Consultee response

WA/65/20/PL

Little Box Cottage Walberton Green Walberton BN18 0AT

Change of use of upstairs of barn/garage building as occasional holiday let, use of half of one of the 3 lower bays of the garage as a workshop/office & addition of 2 wooden garage doors to the 2 open bays on the front elevation with addition of window to rear elevation (easterly bay)

PROPOSED : Garage

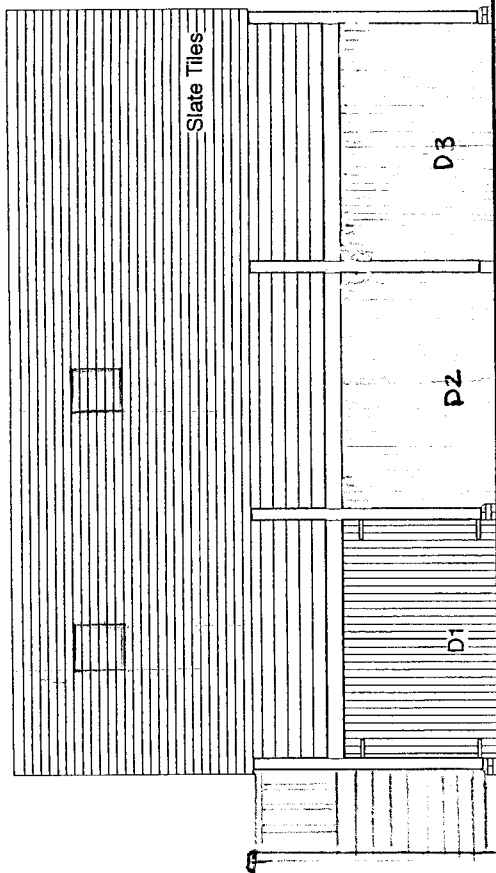
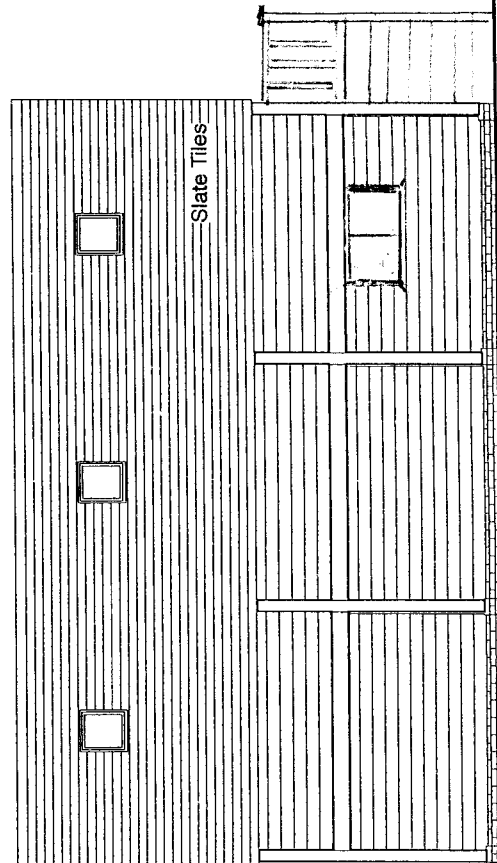
There is a modern 3 bay wooden barn style garage within the grounds of the listed building. This application seeks permission for the introduction of two sets of doors to two of the bays, a window on the ground floor and for the change of use of the first floor space to occasional holiday let.

The additional doors and window will not affect any historic fabric and appear to be suitable for the modern building. They are also of a scale/appearance which will not impact on the appreciation of either the listed building or the conservation area.
